# CITY OF ALBUQUERQUE

May 8, 2023

**Re: XRAMM**  
**5800Jefferson St. NE**  
**30-Day Temporary Certificate of Occupancy**  
**Transportation Development Final Inspection**  
 Engineer's Stamp dated 12-16-21 (E17-D011B)  
 Certification dated 05-08-23

**AS102**

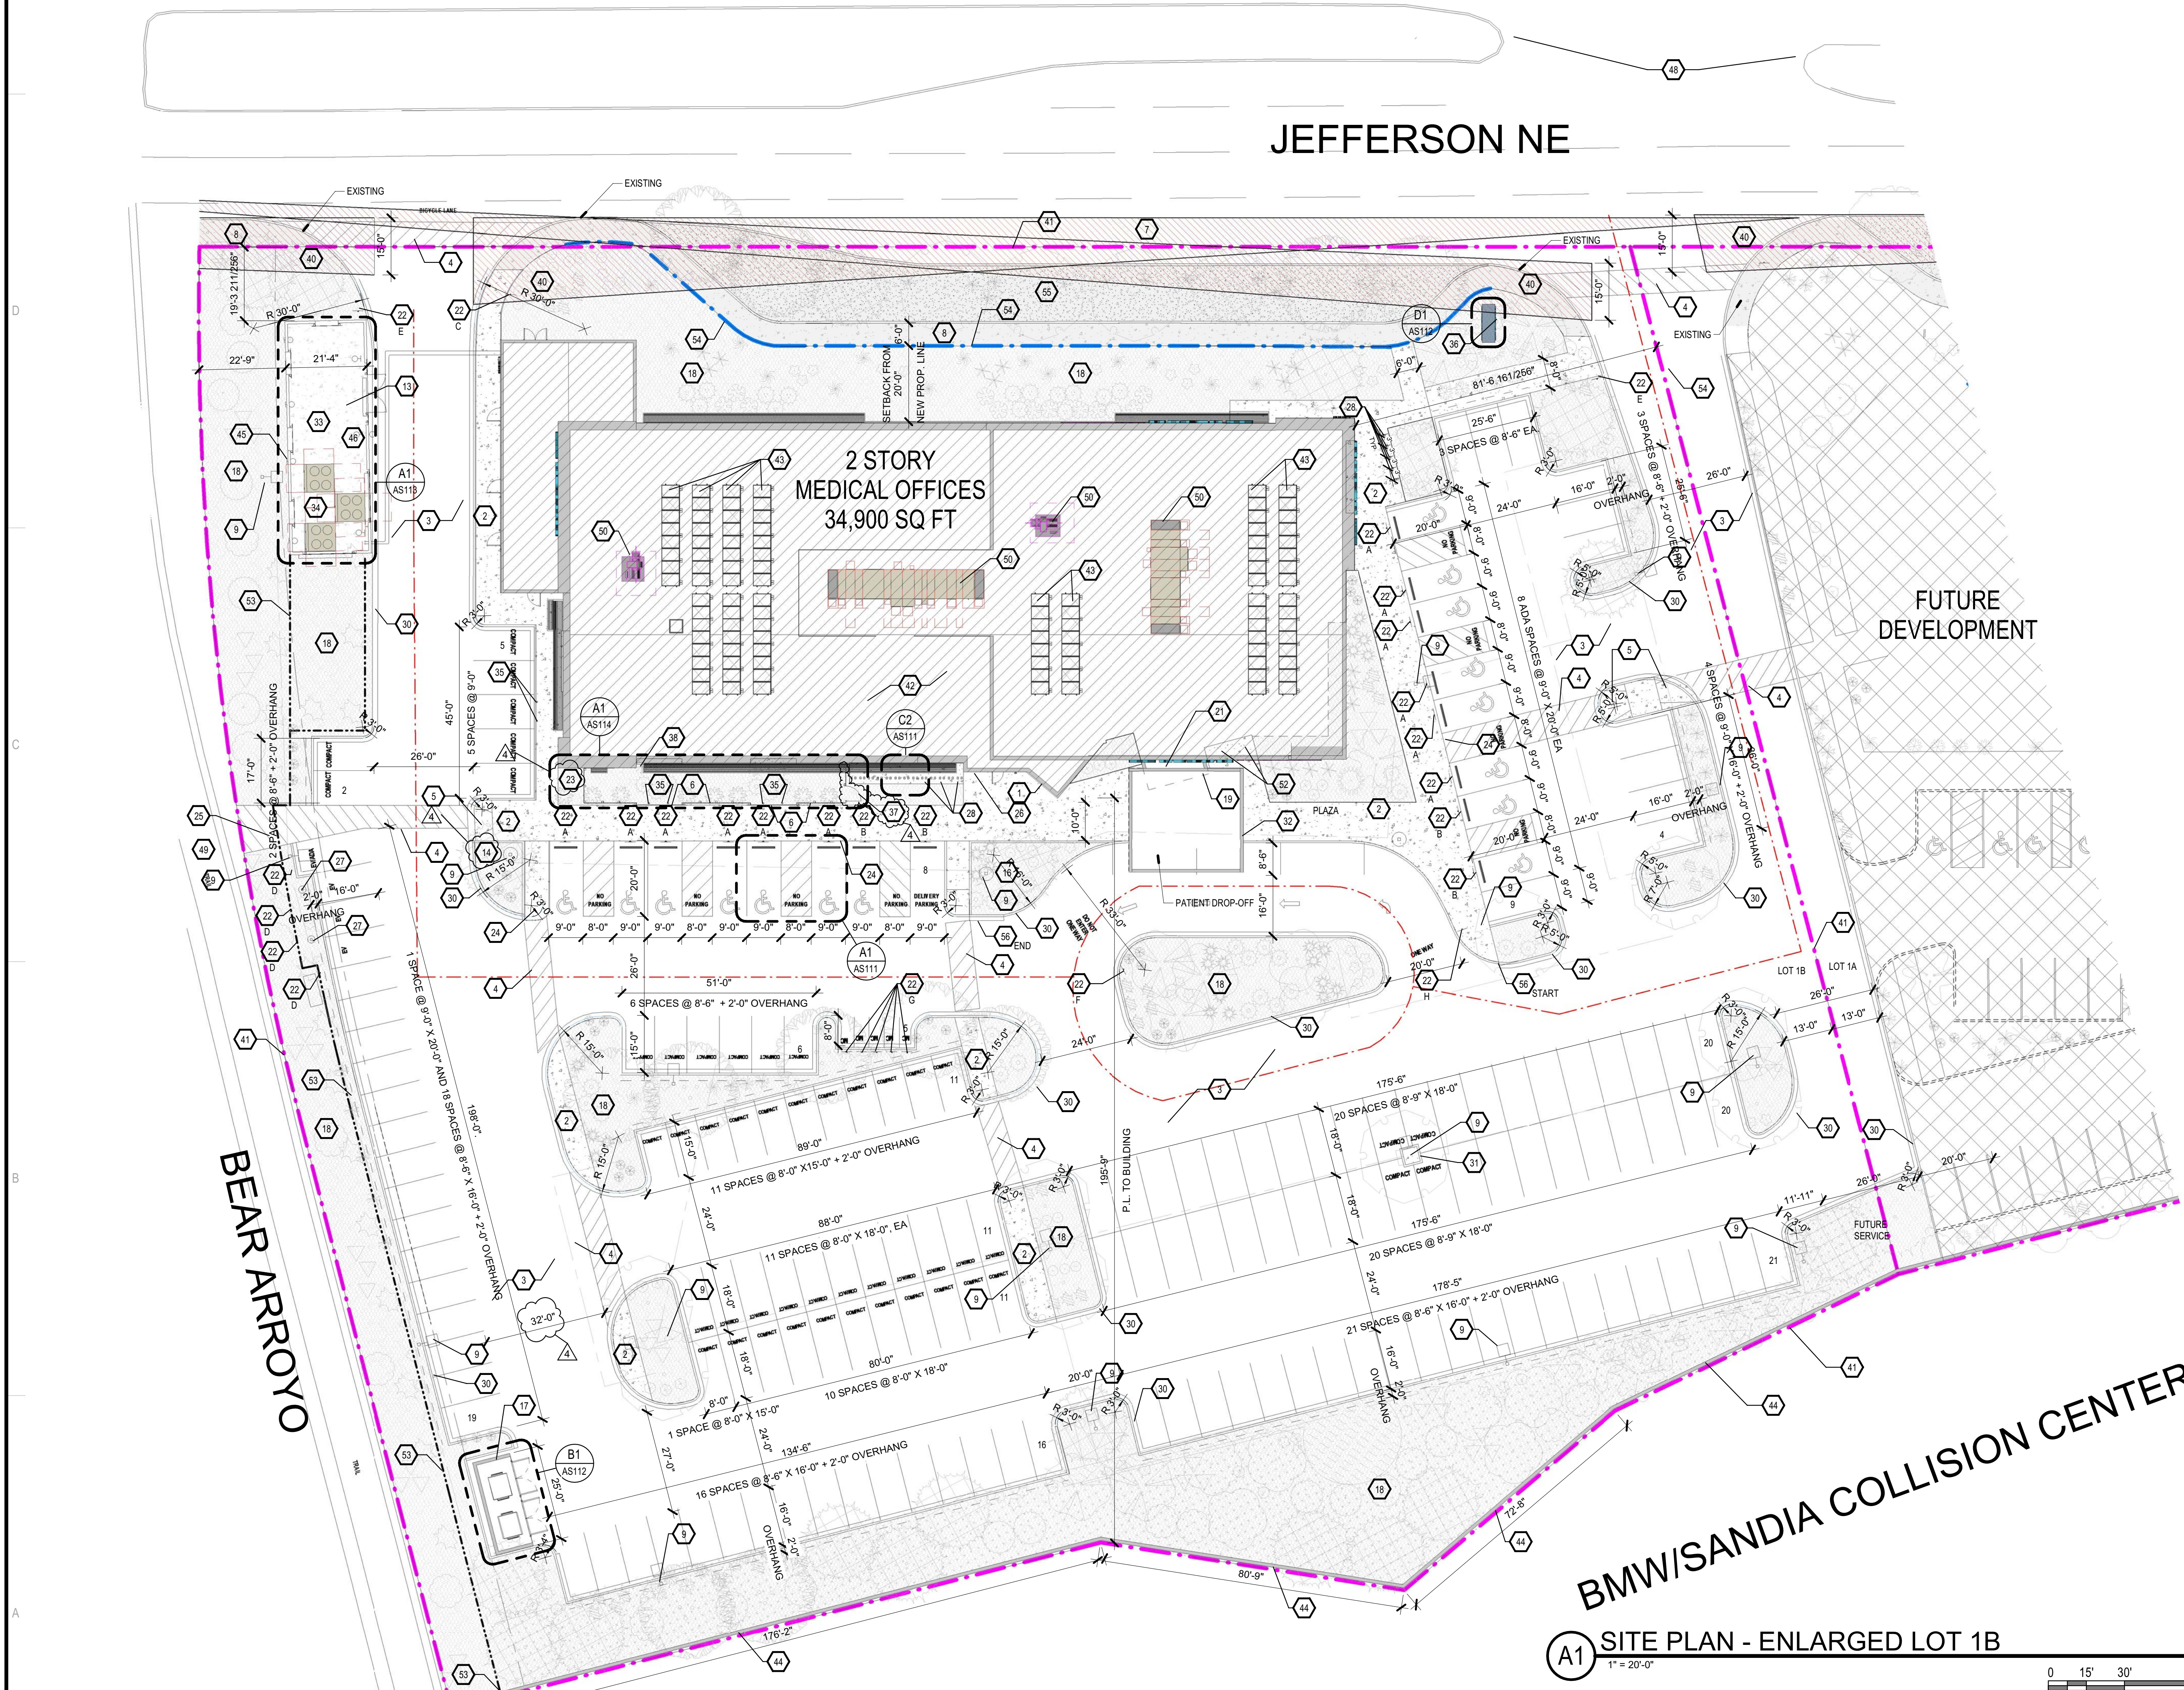
- Approved site plan shows 9 parking spaces on the south side of the Generator (keynote 33), Per site visit, only two parking spaces and a pond exist. Please provide parking calculations showing that the provided parking spaces meet the requirements.

And Please red mark the site plan to reflect the changes made during construction.

- Per the site visit, the width for this drive aisle was 23 ft. Please red mark the site plan to reflect the changes made during construction.

- Please complete painted crosswalk per approved plan keynote 4.

- Per site visit, there were 42 compact parking spaces, please provide parking calculations showing how many parking spaces are required by zoning because only 25% of the required parking could be a compact parking space.
